From: Carmichael Ian
Sent: 10 July 2020 11:17
To: Rebekah Morgan
Cc: Planning
Subject: Planning ref: 16/00472/OUT (AMENDMENTS). S Grundon Services Ltd Merton Street Banbury OX16 4RN.

Planning ref: 16/00472/OUT Proposed residential redevelopment for approximately 200 units. S Grundon Services Ltd Merton Street Banbury OX16 4RN.

Crime Prevention Design Advisor | Oxfordshire | Local Policing | Thames Valley Police

Parking & Undercroft Parking

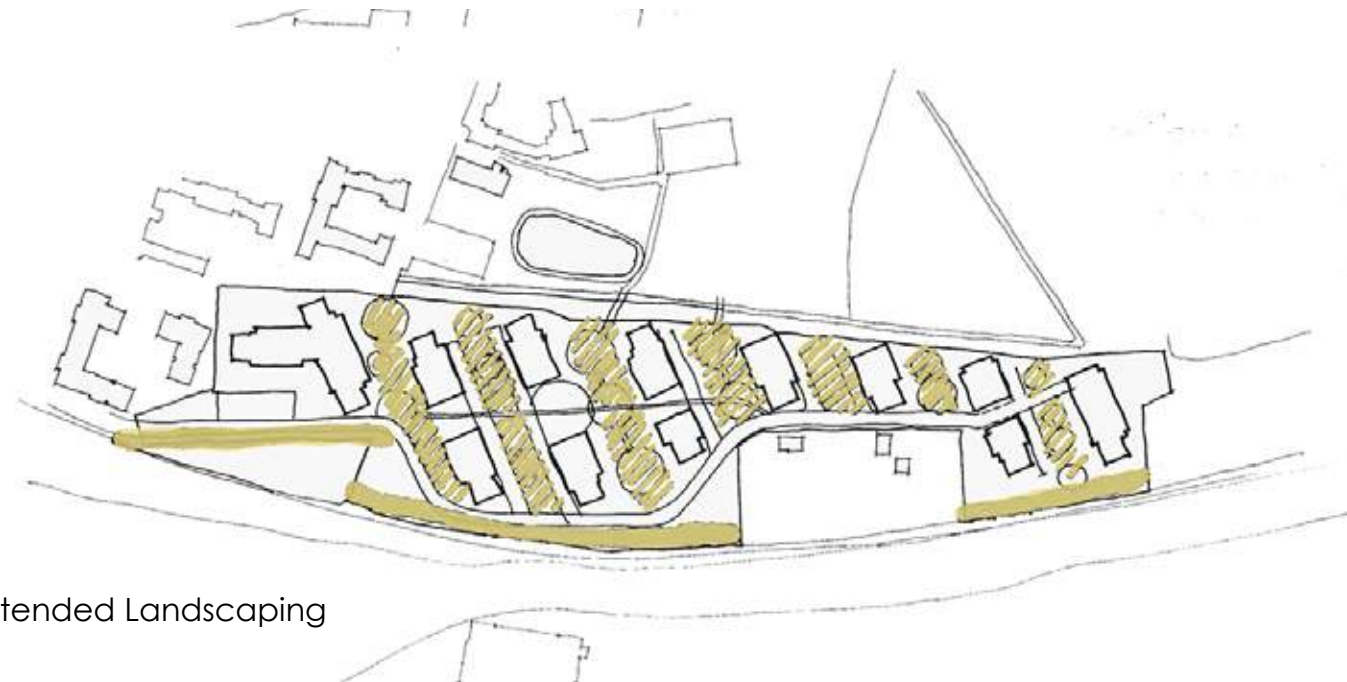
- I am concerned about the provision of undercroft parking. These features can attract anti-social behaviour (ASB) and make vehicles and people vulnerable. This design also creates a development with little or no active frontage to the street at ground level, which can have a negative effect on community interaction. I would prefer to see designs amended to omit the undercrofts or convert them to secure garages. If they must remain, they should be made secure, have appropriate lighting and be overlooked by active rooms of dwellings.
